Whitehaven Coal Limited (Whitehaven) has prepared this letter to provide **comments** on the *Boggabri Coal Mine Modification 8 Amendment Report* (Modification 8 Amendment Report) and associated specialist assessments. Maules Creek Coal Pty Ltd (MCC), operator of the Maules Creek Coal Mine (MCCM) and Tarrawonga Coal Pty Ltd (TCPL), operator of the Tarrawonga Coal Mine (TCM) are subsidiaries of Whitehaven. The MCCM and TCM are located adjacent to the Boggabri Coal Mine (BCM), north and south of the BCM, respectively. The BCM, MCCM and TCM are collectively referred to as the BTM Complex.

Table 1
Whitehaven Comments on the Modification 8 Amendment Report

Figure 2 | Approved vs Amended Conceptual Final Landform

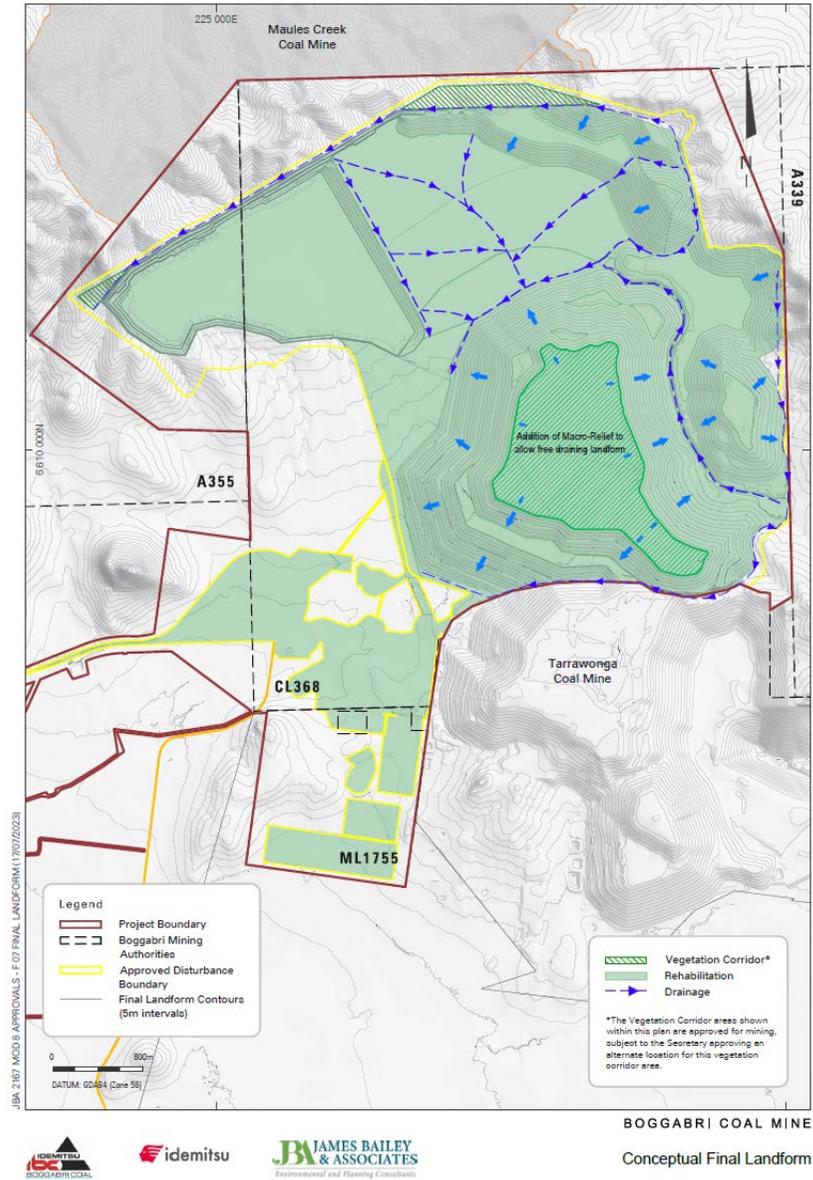
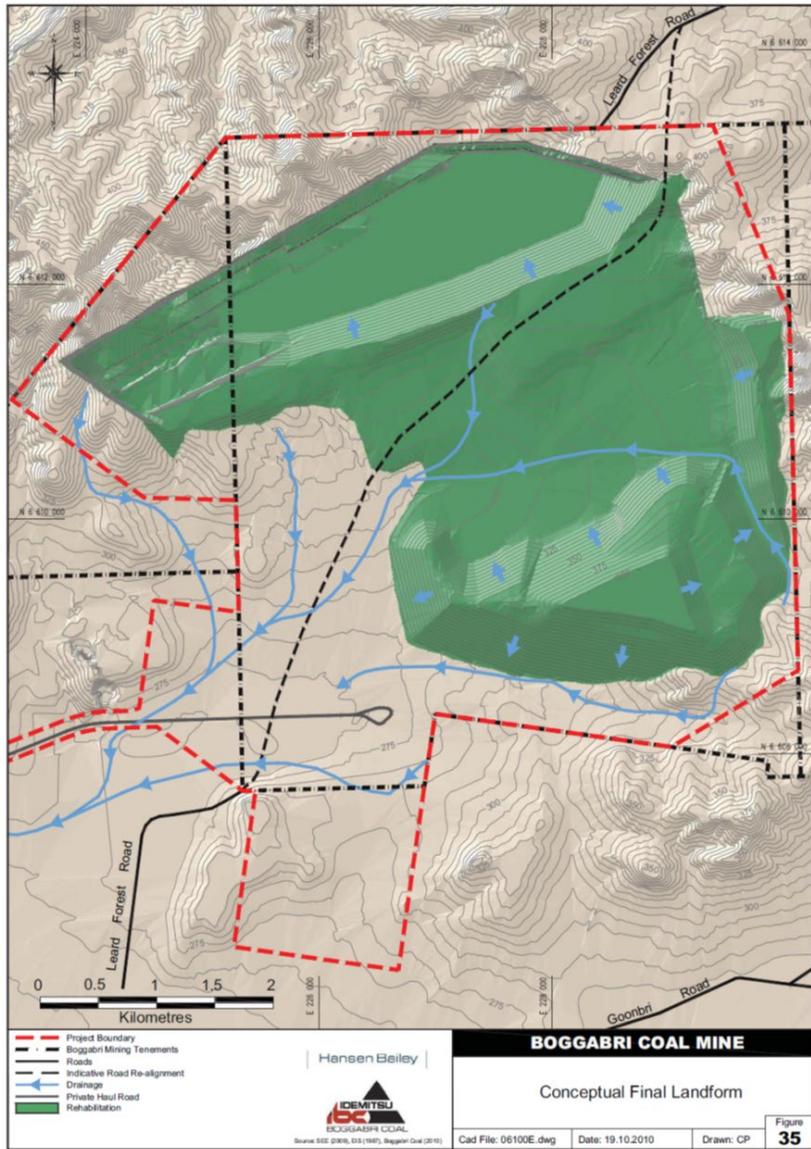
The Surface Water Impact Assessment ² includes variations in the Conceptual Final Landform Design (Figures 3-1 to 3-4) and shows that that the proposed Completed Rehab Area infringes on the northern TCM boundary.	Further detail regarding the Conceptual Final Landform Design Completed Rehab Area along the TCM boundary should be provided including whether the use of Whitehaven-owned land is proposed.	Comment does not appear to be addressed in the Modification 8 Amendment Report documentation.
The Modification Report describes that a valley will remain between the BCM and TCM waste emplacements. The Evaluation of Final Landform assessment notes that ² : <i>...some planning will be required to manage runoff reaching that valley from the adjoining batter slopes.</i>	Whitehaven is requesting further consultation is undertaken regarding managing this runoff.	Whitehaven is requesting further consultation is undertaken regarding managing this runoff.
